SOUTH HOLLAND DISTRICT COUNCIL

Purpose: To consider Planning Application H07-0192-22

Description: Proposed Use of Land for the Stationing of Accommodation for Armed Forces Veterans to Create a Reintegration Facility

Location: TEREMOK STATION ROAD GEDNEY HILL

**Drawing**  
Accommodation building

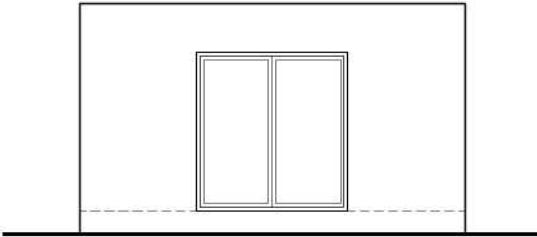
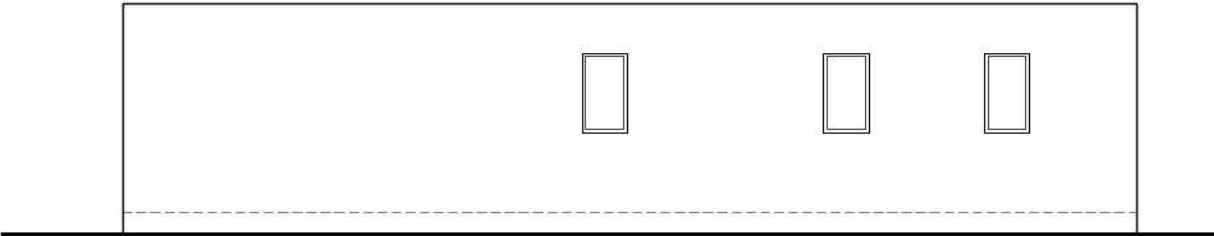
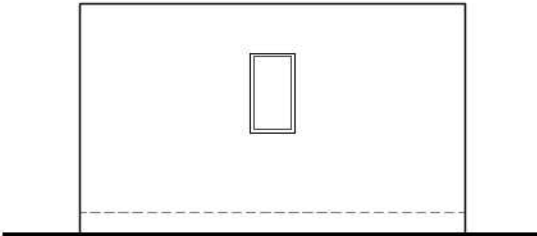
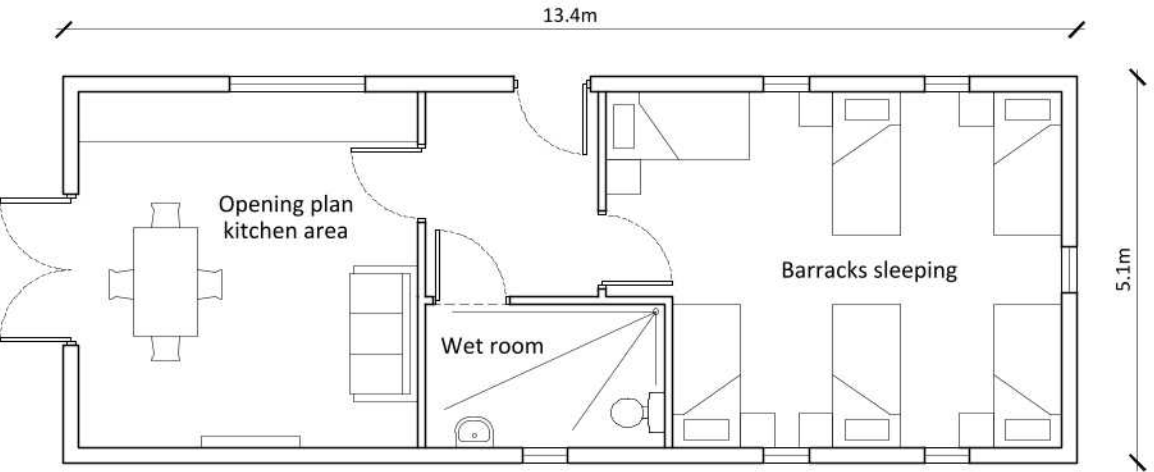
- 7.11 The proposed development involves the change of use of land for the stationing of accommodation for Armed Forces Veterans to create a reintegration facility. The proposal includes the erection of a managers' accommodation building, erection of an accommodation building, provision of off-street car parking spaces and landscaping works. The proposed buildings would be single storey in height, be of a flat-roof design and measure 13.4m by 5.1m with a height of 3m.

- 7.12 The proposed buildings are considered to be of an acceptable scale and design and would benefit from adequate screening from the public highway of Station Road afforded by mature, dense tree planting along the eastern boundary. Whilst the proposed development would be visible from the rear of the site, along West Drove South, given the proposal would replace existing buildings on site and would be approximately 350m from the highway of West Drove South, the proposal would not result in detrimental impacts on the character of the area.

Managers accommodation

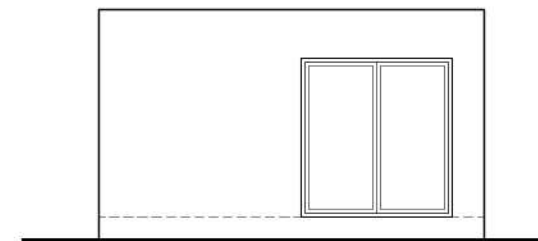
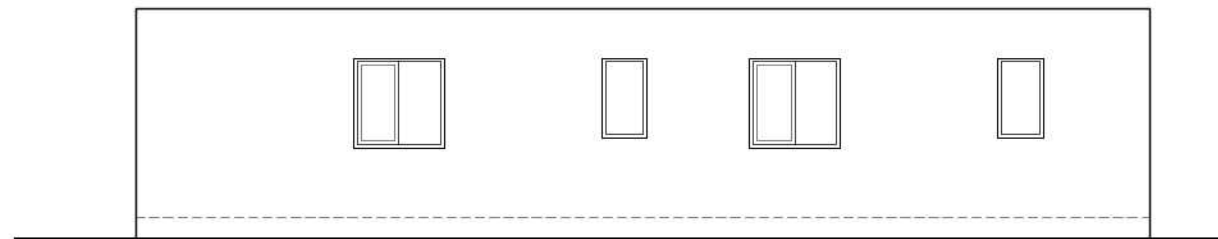
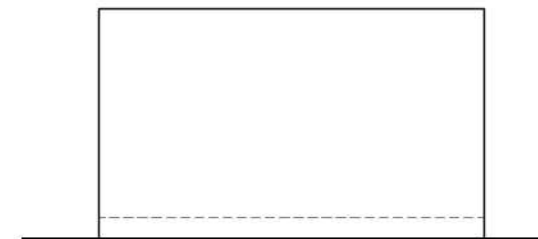
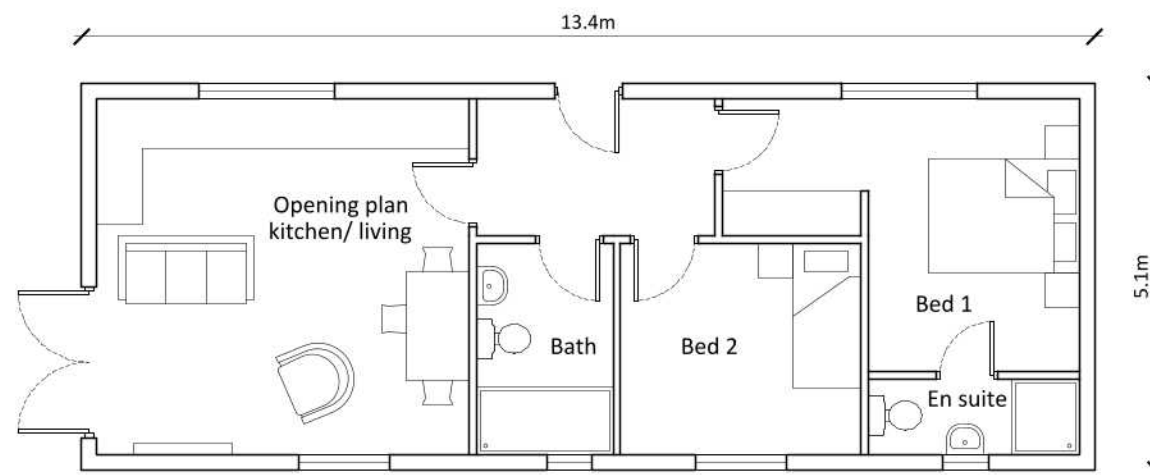
- 7.17 Given the single storey nature of the proposed buildings to be constructed, the proposal is not considered to result in any detrimental overbearing, overshadowing or overlooking impacts on either neighbouring property. Furthermore, given the scale and nature of the proposal, the development is not considered to result in a significant number of comings and goings that would result in general noise and disturbance impacts on the neighbouring properties.
